FourSquare at Sterling Ranch East, PUDSP-22-7 (revised)

Please accept the following comments from El Paso County Public Health regarding the project referenced above:

Mike McCarthy, 03August2022
El Paso County Public Health
719.332-5771
mikemccarthy@elpasoco.com

TRACT H
PROPOSED FULL SPECTRUM
DETENTION POND 16A
488,118 SF
11.21 AC

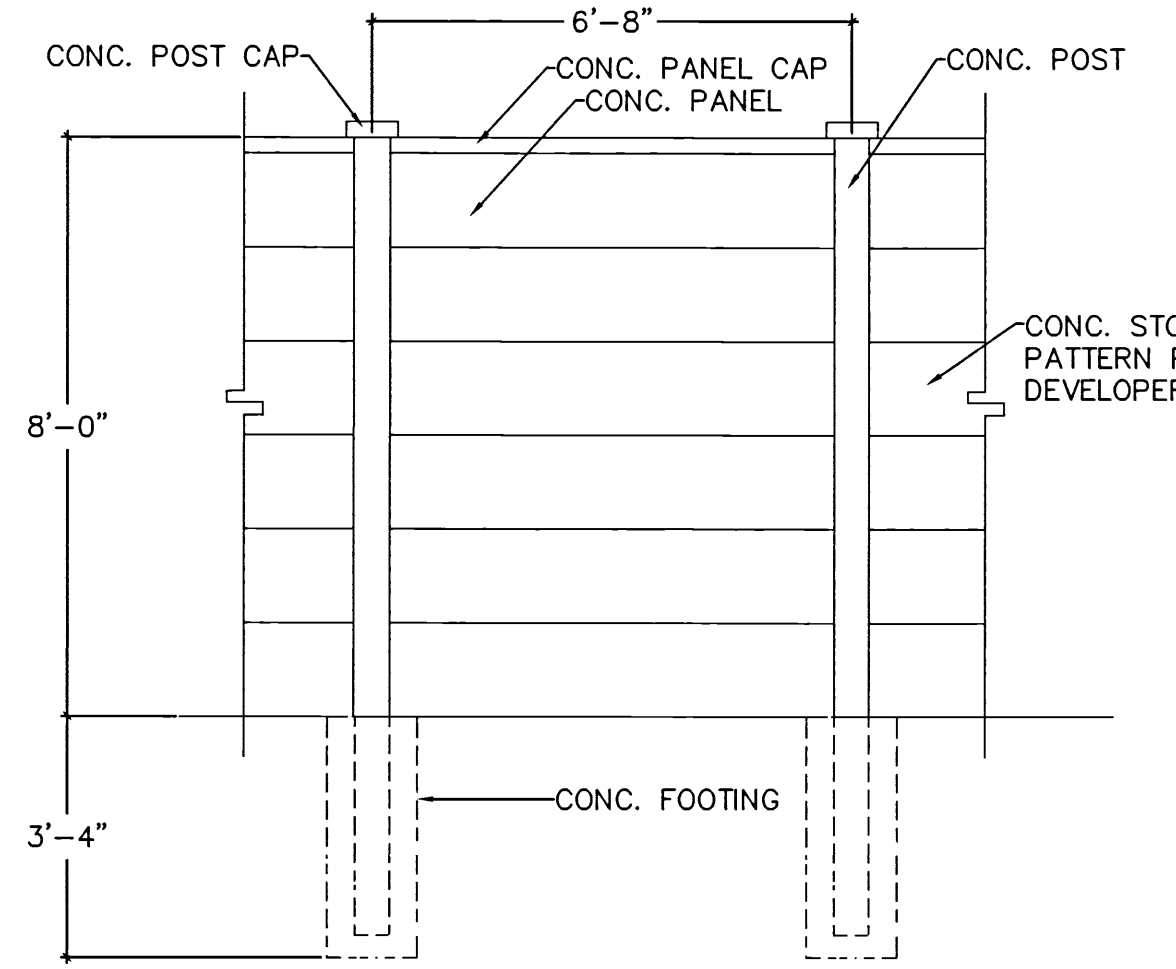
- The water quality basin in Tract H must have mosquito control responsibilities included as a part of the construction design and maintenance plan to help control mosquito breeding habitat and minimize the potential for West Nile Virus.
